## El Paso County Park Advisory Board

### Agenda Item Summary Form

**Agenda Item Title:** Grandview Reserve Filing No. 1 PUD Preliminary Plan

**Agenda Date:** October 13, 2021

LANDSCAPE OVERVIEW PLAN

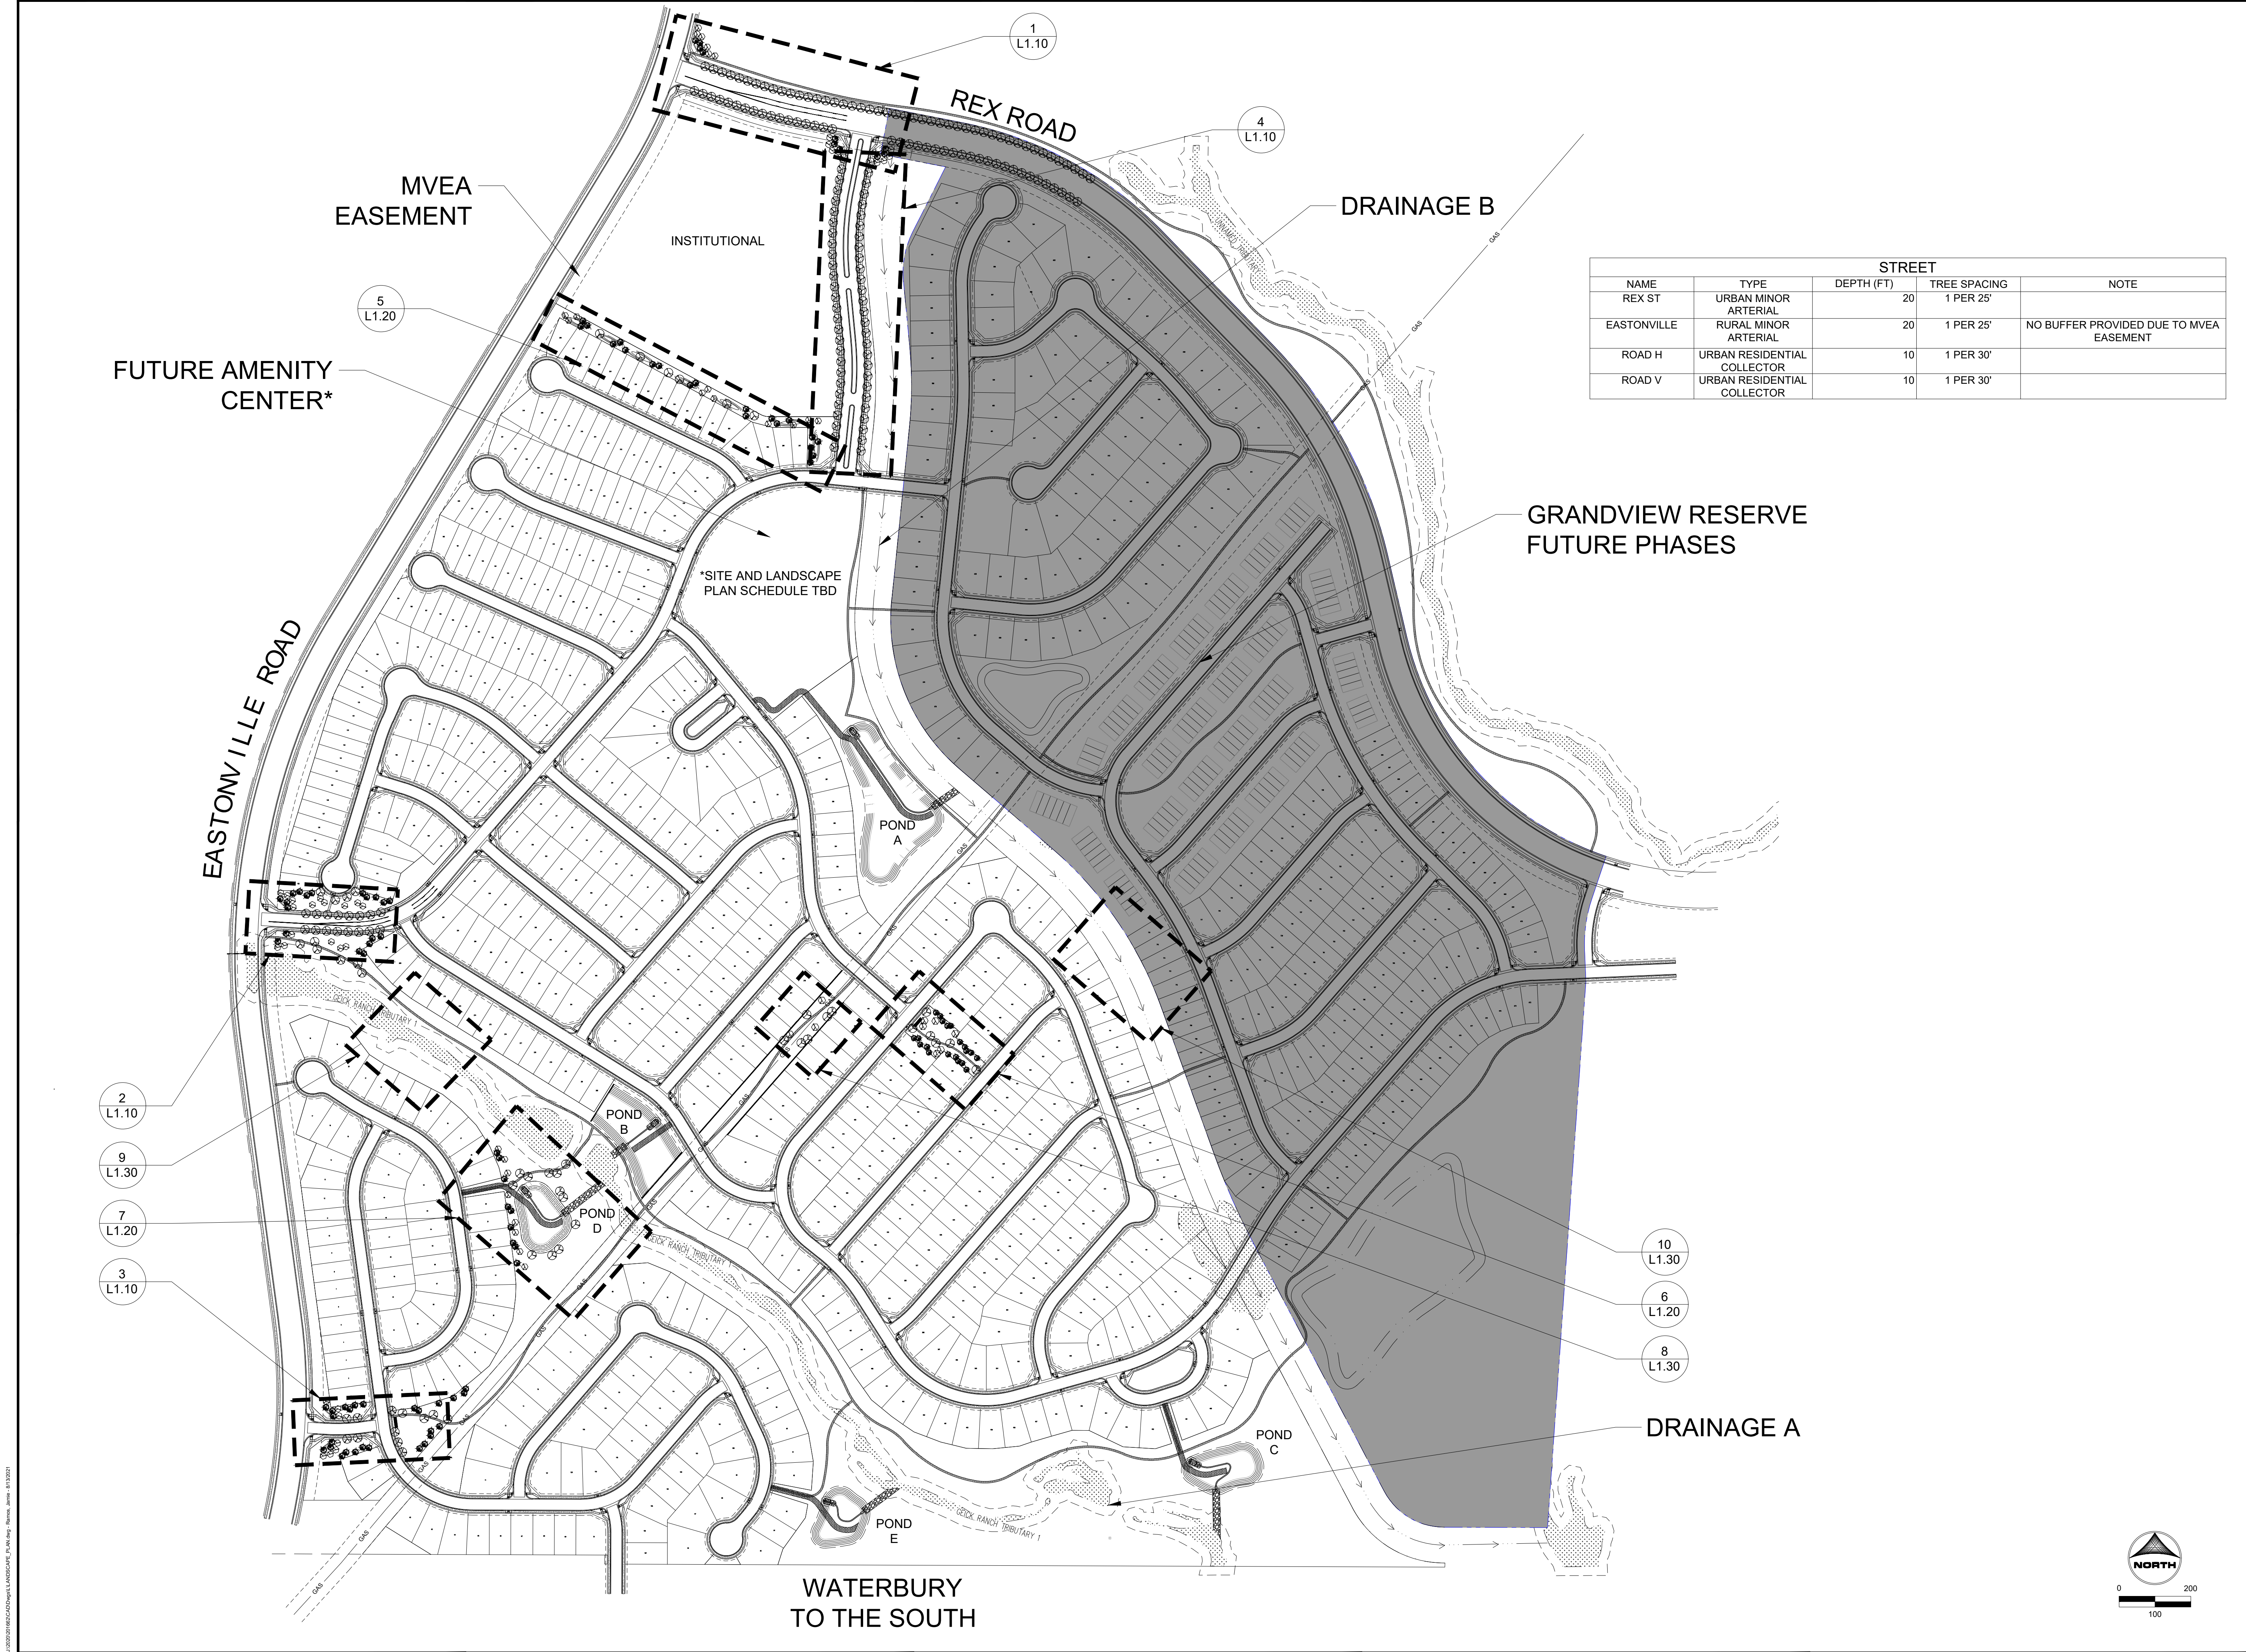
Moreover, staff recommends that the applicant submit detailed site plans for the proposed Amenity Center, as the currently proposed neighborhood pocket park does not include multi-generational recreational amenities such as a playground, multi-use turf field, or seating and picnic areas. The submitted Landscape Plans only show landscaping and a connecting pathway within the proposed pocket park.

The Park Advisory Board recommends that the Planning Commission and the Board of County Commissioners include the following conditions when considering and/or approving the Grandview Reserve Filing No. 1 PUD Preliminary Plan: (1) provide detailed site plans for the proposed Amenity Center; (2) work with El Paso County Parks and Public Works staff to develop a final layout and design for the Eastonville Primary Regional Trail along the southeastern side of Eastonville Road; (3) designate and provide to El Paso County a 25-foot trail easement along Eastonville Road, that allows for construction, maintenance, and public access of the Eastonville Primary Regional Trail; (4) the trail easement shall be shown on all forthcoming Preliminary Plans and Final Plat, and the aforementioned easement shall be
